# Cabarita Beach Mixed Use Development Modification 6

Cabarita Beach Mixed Use Development Modification 6  
Assessment Report  
State Significant Development Modification Assessment  
(MP 07\_0179 MOD 6)

February 2021

Published by the NSW Department of Planning, Industry and Environment

project no	scale	@A3
P1710	1 : 400	
dwg no		rev no
DA-05		B

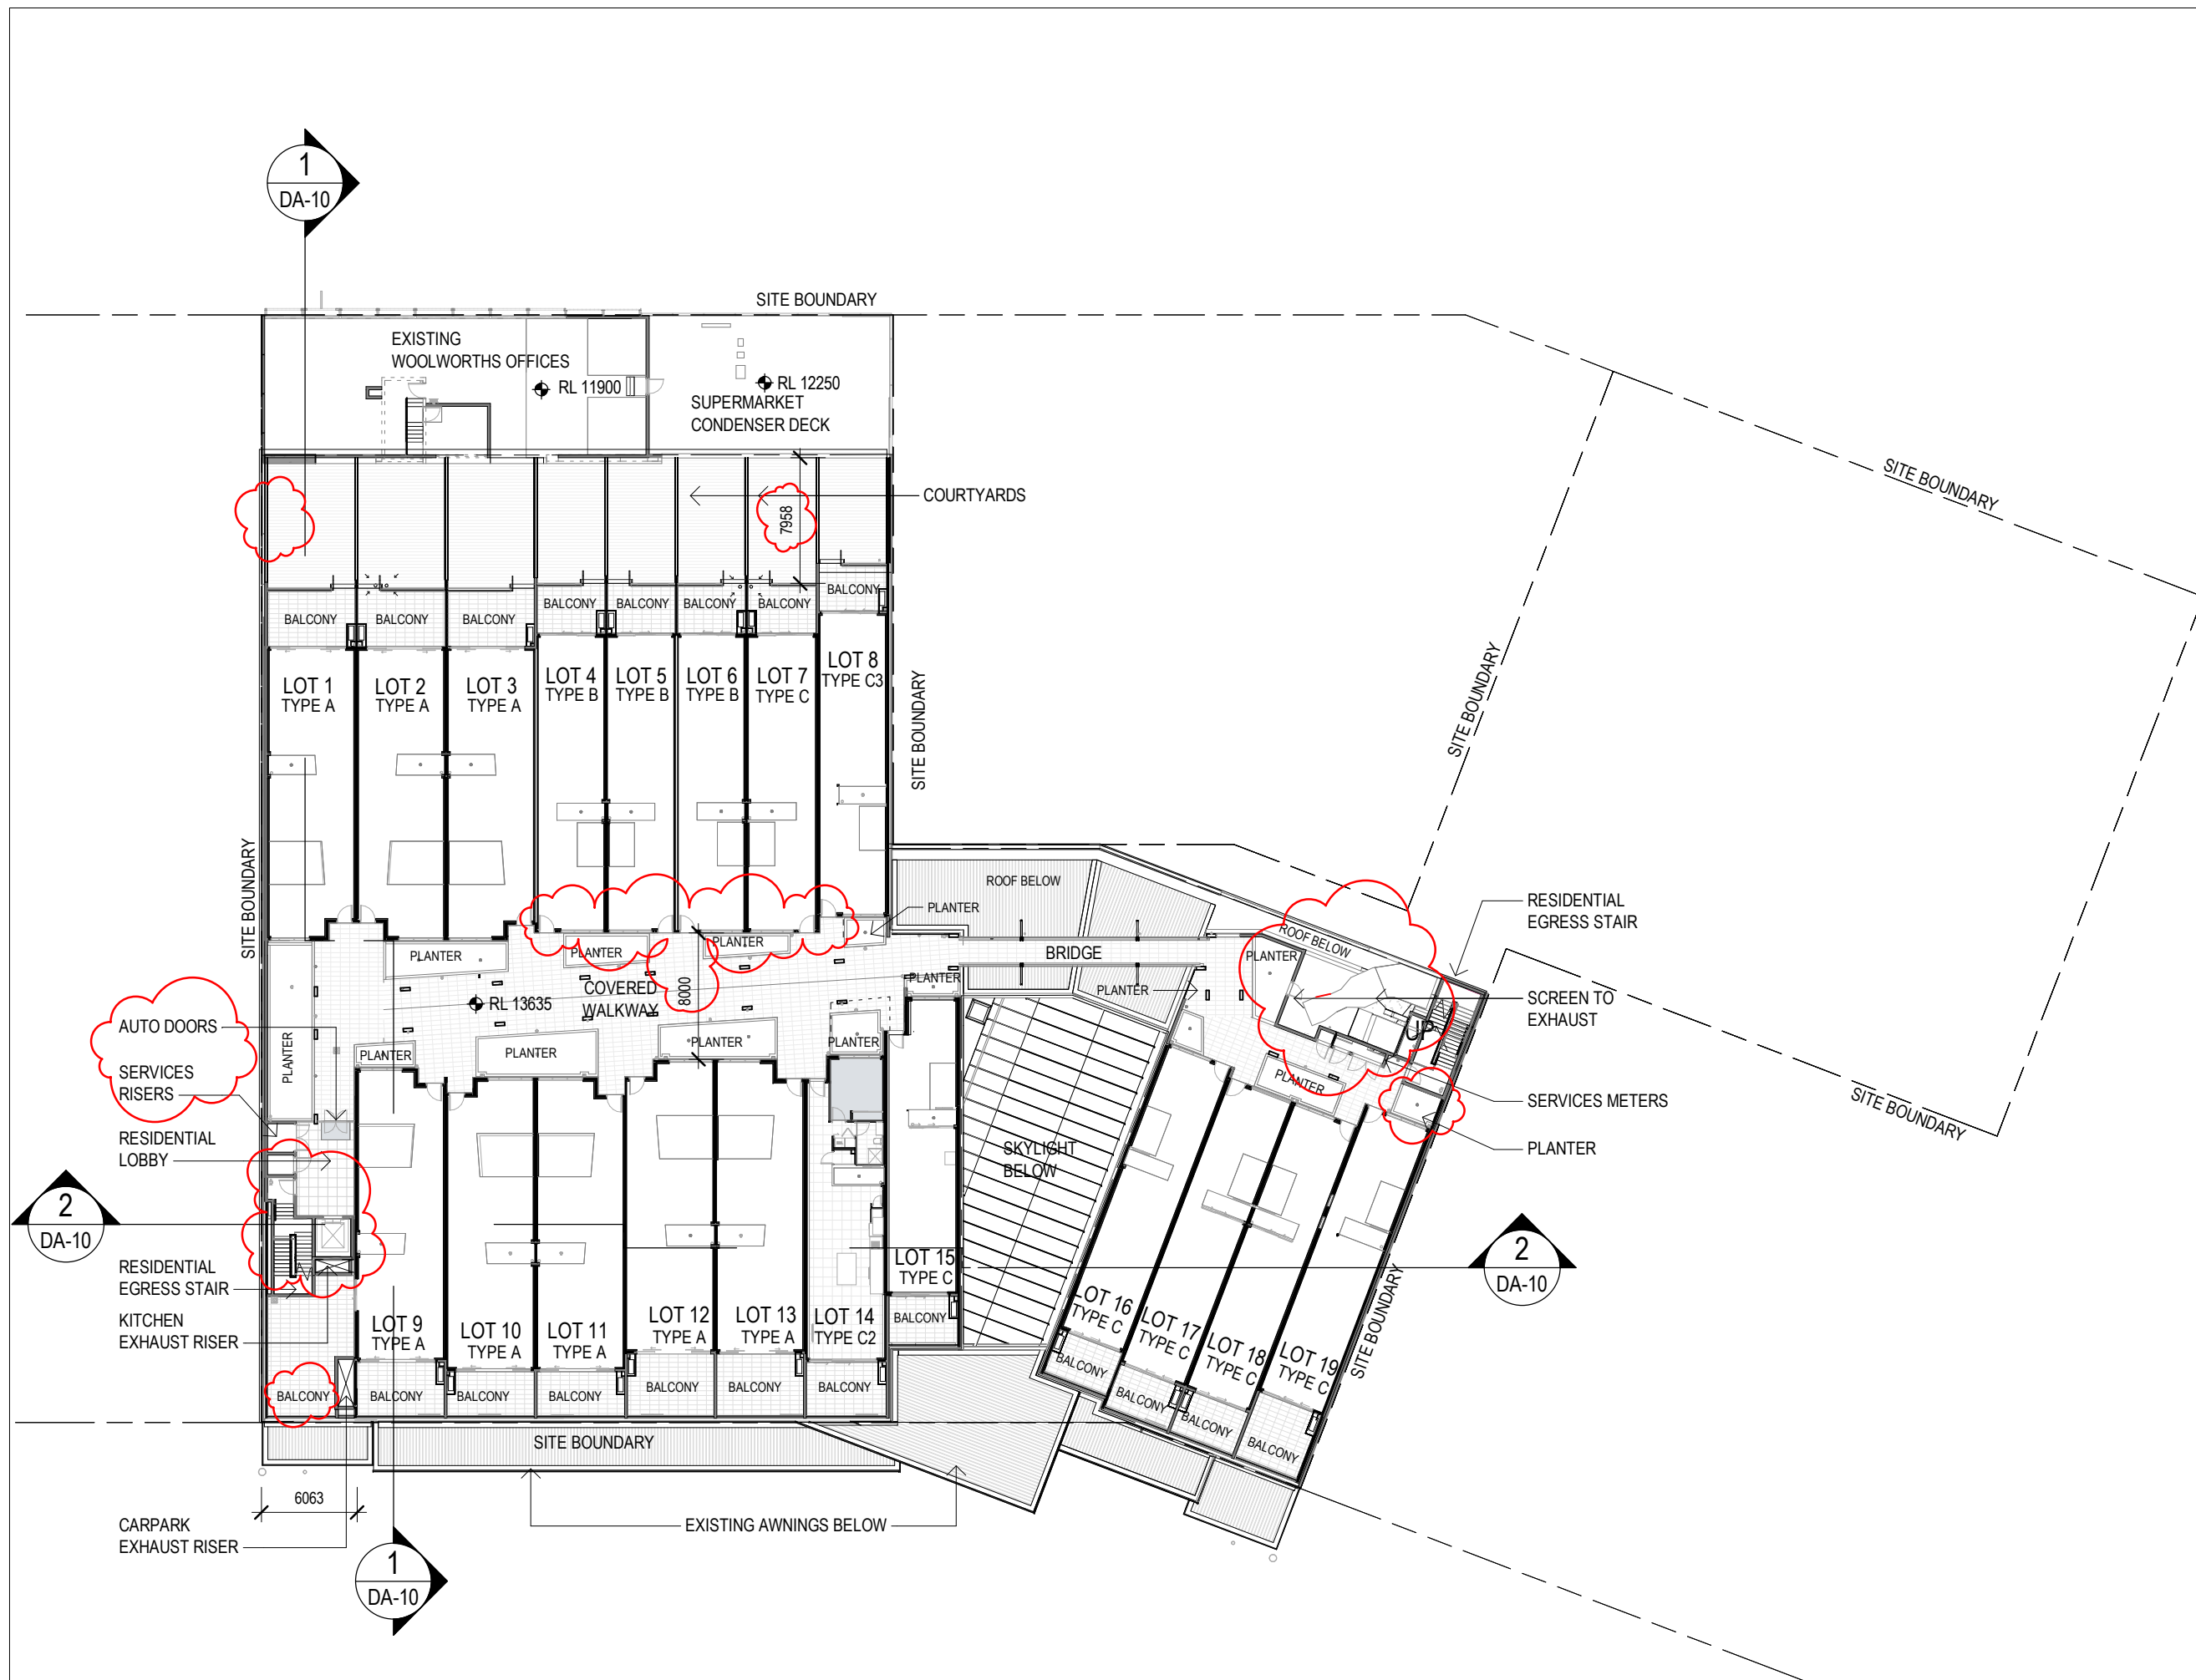
- Not supporting the reallocation of the landscaped area on Level 1 adjacent to the Hastings Road frontage to private open space for units 1-8. Council indicated a preference for this area to be used as communal open space with access for all residents.
- Proposed changes to the roof profile, with the current proposal being more monotonous and contributing little to the landscape, particularly when viewed from Hastings Road.

Public and Council submissions raised concerns about the potential impact of the proposed reallocation of landscaped open space to private open space for units 1-8 referred to as 'courtyards' on the properties on Hastings Road. The key concerns are visual enmity, noise and privacy impacts.

Council did not support this reallocation as it represents a missed opportunity for public open space and limited detail was provided in relation to the visual impact of the revised proposal when viewed from street level of Hastings Road. Council noted that it may be more appropriate to allow individual access from units 1-8 as proposed, but to retain the area as a single landscaped area which allows for access for other unit occupiers.

The Applicant has provided additional plans detailing sightlines from the neighbouring properties on Hastings Road. The plans demonstrate neither the courtyards nor the units are visible from the opposing properties. As the courtyards are not visible from surrounding properties, the Department is satisfied that utilising this area as a landscape buffer for visual amenity purposes is of minimal advantage, as it would provide no benefit to adjoining properties. Similarly, landscaping this podium will provide no benefit to privacy as there are no significant impacts in this regard.

The Department is satisfied that this proposed reallocation of space is appropriate in this case, as the space is not being used to provide any benefits to surrounding properties and will not cause

significant noise, privacy or visual amenity impacts as the space is not visible from adjoining properties.

project no	scale	@A3
P1710	1 : 400	
dwg no	rev no	
DA-07	B

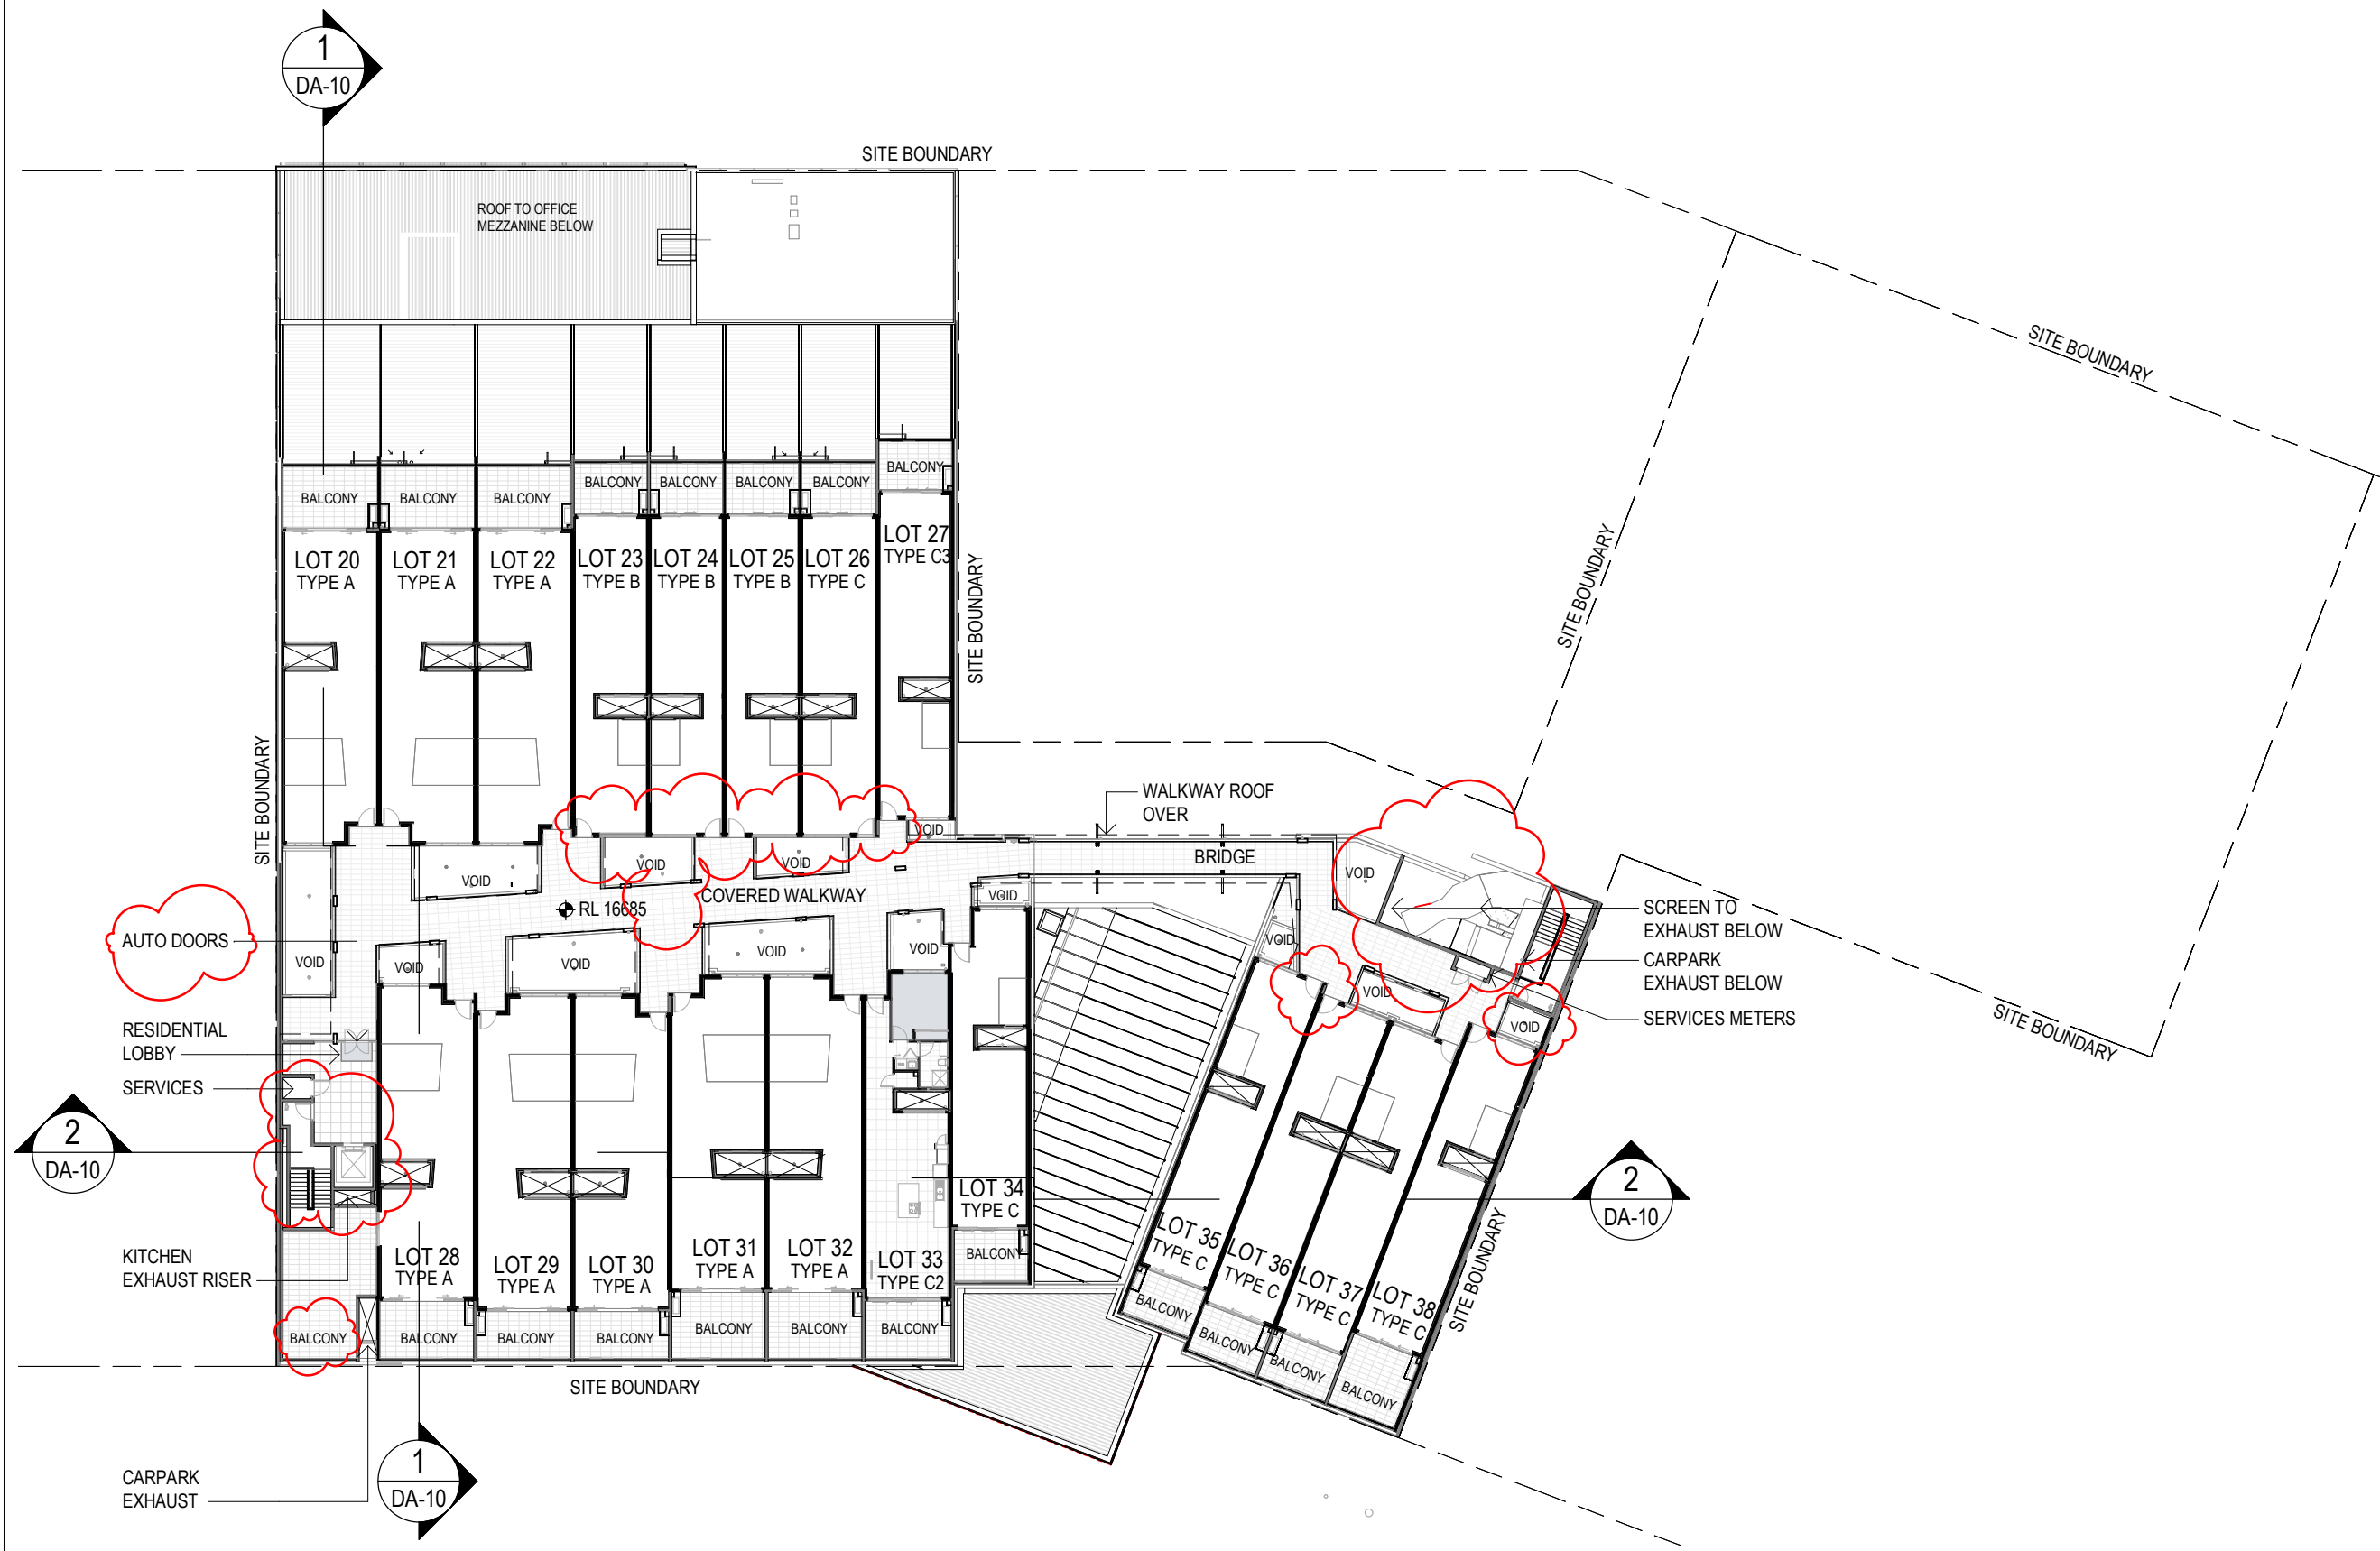
Council raised concerns regarding the reallocation of the Level 1 landscape podium to private open space and the alteration to the roof profile. The public submission raised concerns that the proposal was not 'substantially the same development'.

Council's concerns have been reviewed and the Department is satisfied that the reallocation of the Level 1 landscape podium and minor alterations to the roof profile would not create significant environmental impacts including visual, privacy and noise impacts.
